Engineers Comments Regarding Surface Water Drainage

Application Reference:	LU/72/25/OUT (2)	Reviewer Reference:	ADC/SB
Planning Officer:	Emma Sheppard	Date of Review:	01/12/2025
Site Name:	Land to the West of New Courtwick Lane Wick BN17 7RZ		
Application Description:	Hybrid Planning Application comprising of the following: 1) - Outline application with all matters reserved (except access) for Phase 2 (West of Site) comprising development of approximately 8,800sqm GIA Light Industrial/Storage and Distribution (Use Class E(g)(iii) / B8), and 2) - Full Application for Phase 1 (East of the Site) for a food store (Use Class E(a)), 2 No. Drive-Thru food/beverage units (Sui Generis) with revised vehicular access, associated parking and landscaping. This application may affect the setting of a listed building and is in CIL Zone 2 and is CIL Liable.		
Assessment Number:	3 of 1

2255-P-004A

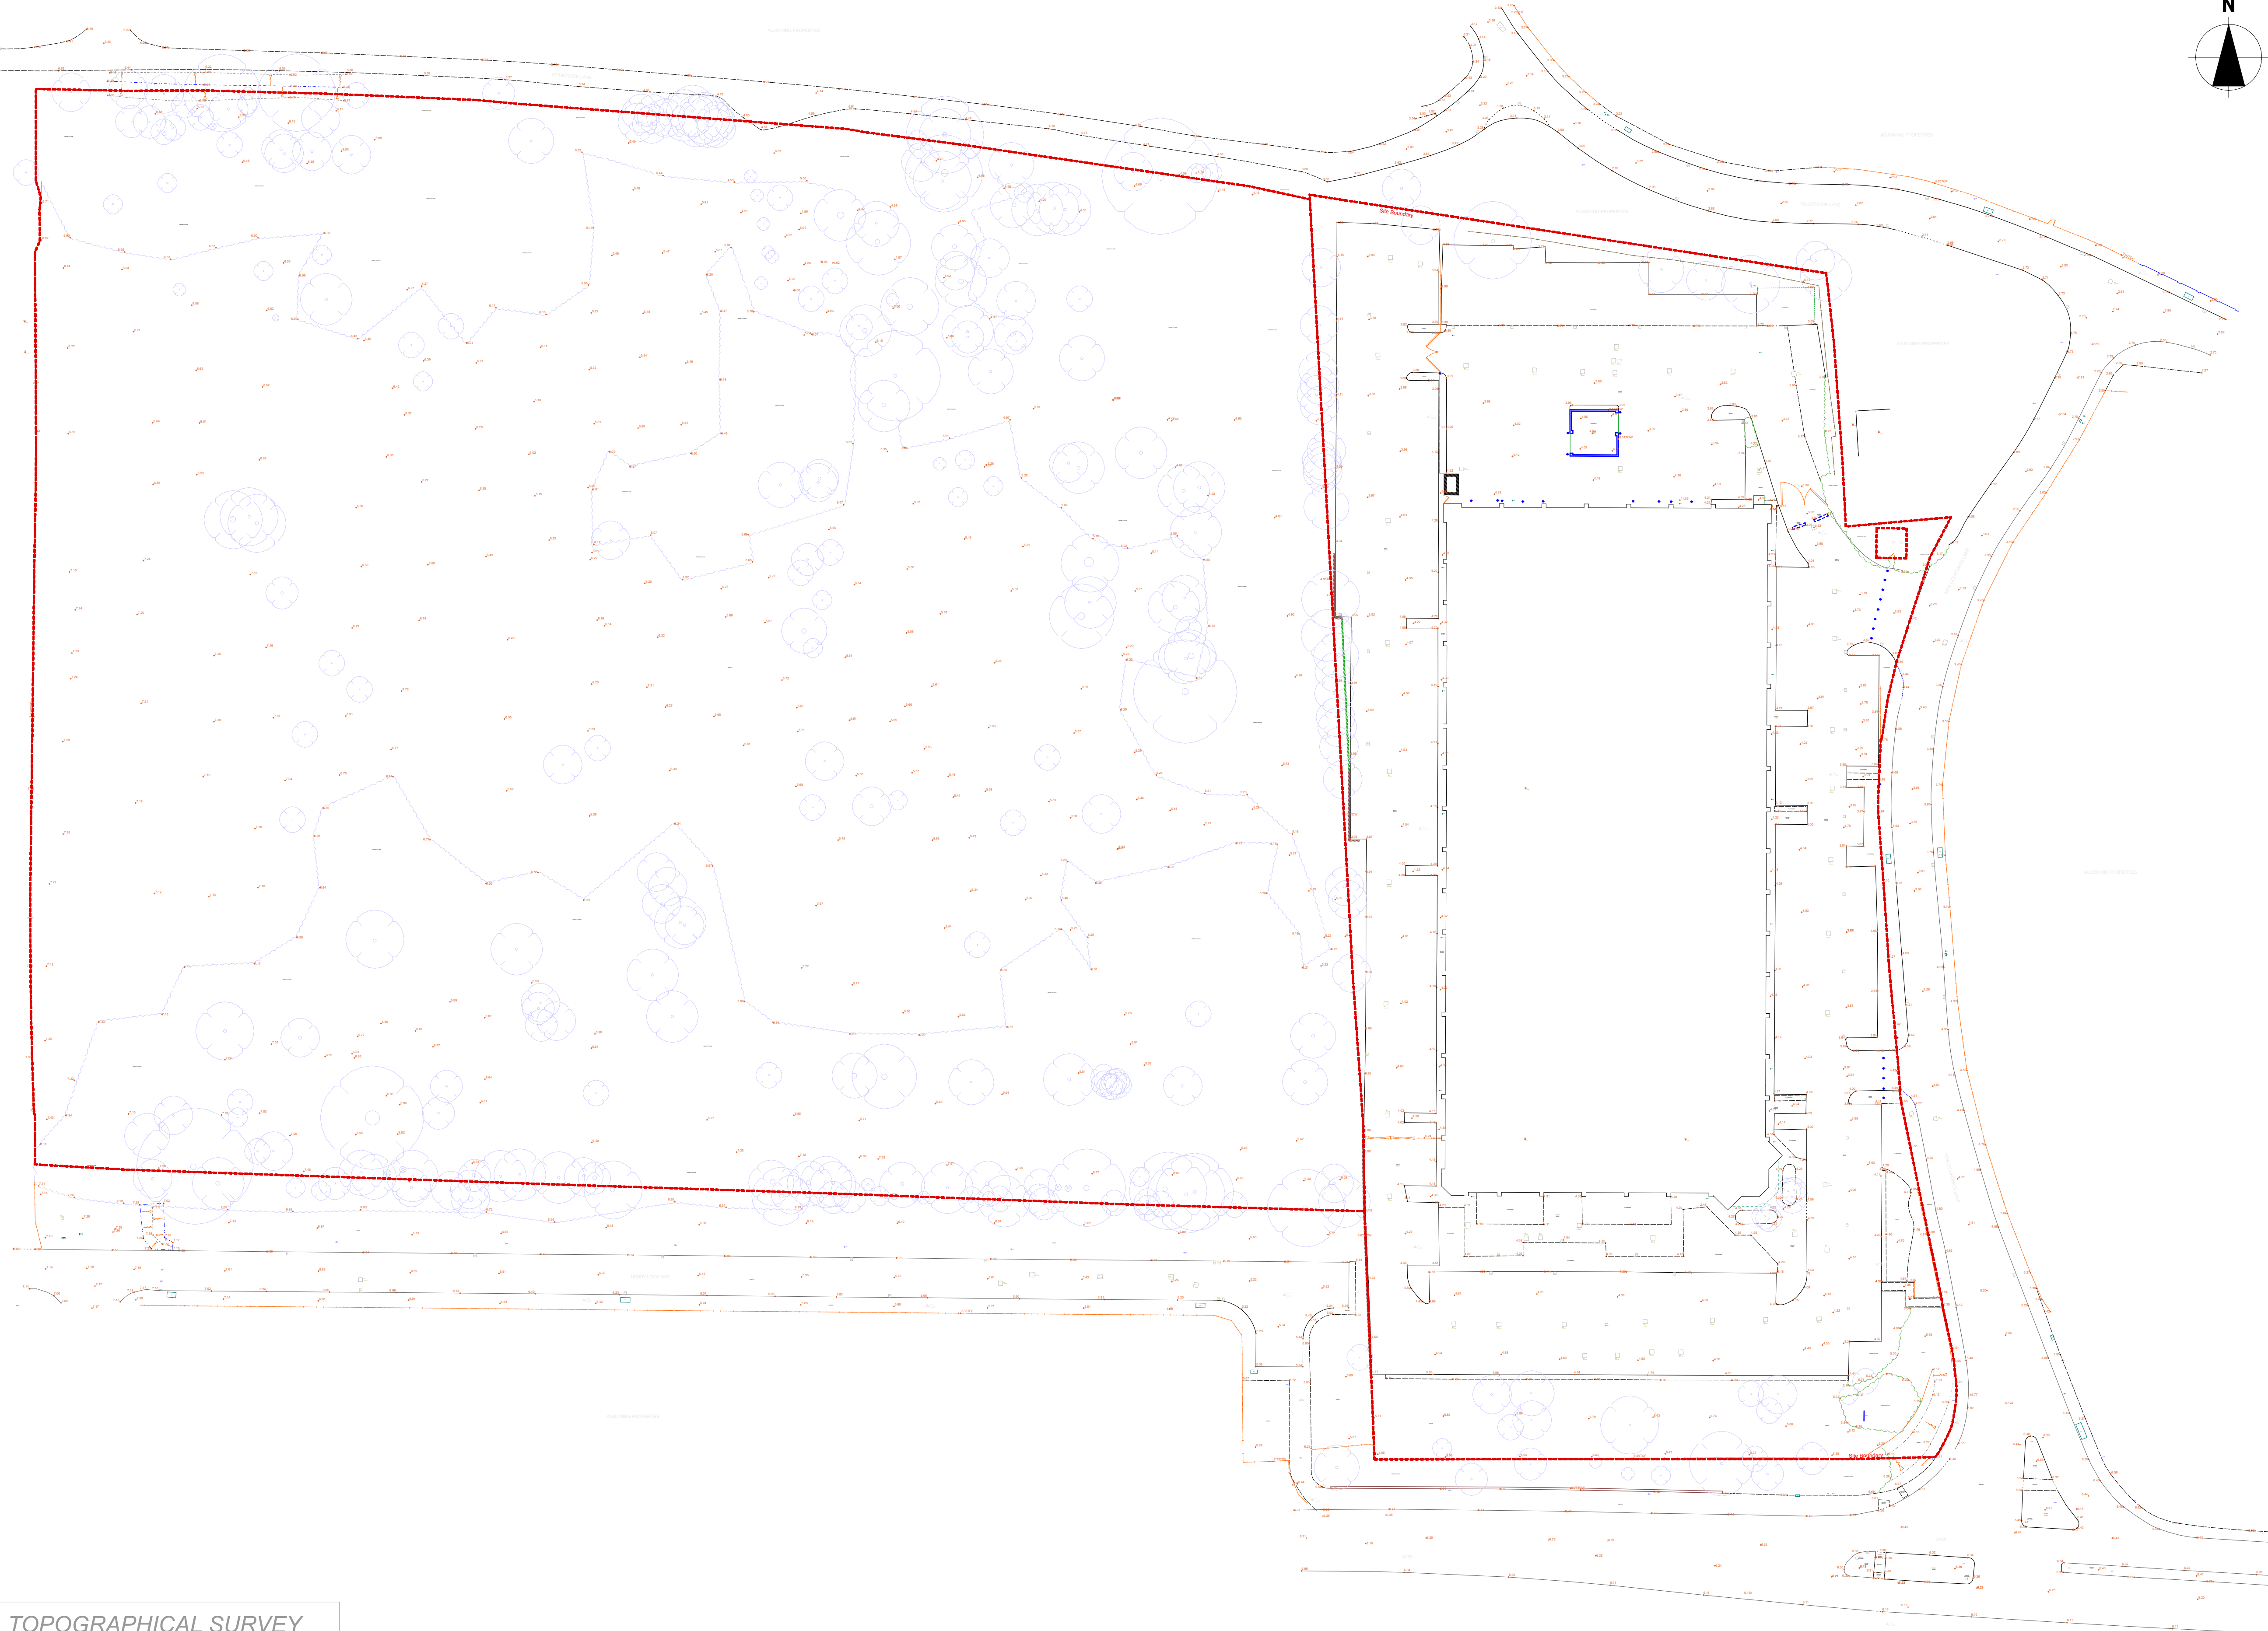
- 0.4. The proposed scope of the infiltration testing is limited by the existing building that is not yet demolished. The spread of testing is sufficient to overcome an objection to the principle of infiltration viability (for this full application). However, it is not sufficient for detailed design purposes.

- 0.5. Should the principle of infiltration be adequately demonstrated then further testing, in the areas beneath where the building currently stands, will be necessary. It is important to record the strata in the trial pits. There is a risk that the strata beneath the building could be made ground to a depth greater than the proposed infiltration blanket which may further restrict the area possible for infiltration.
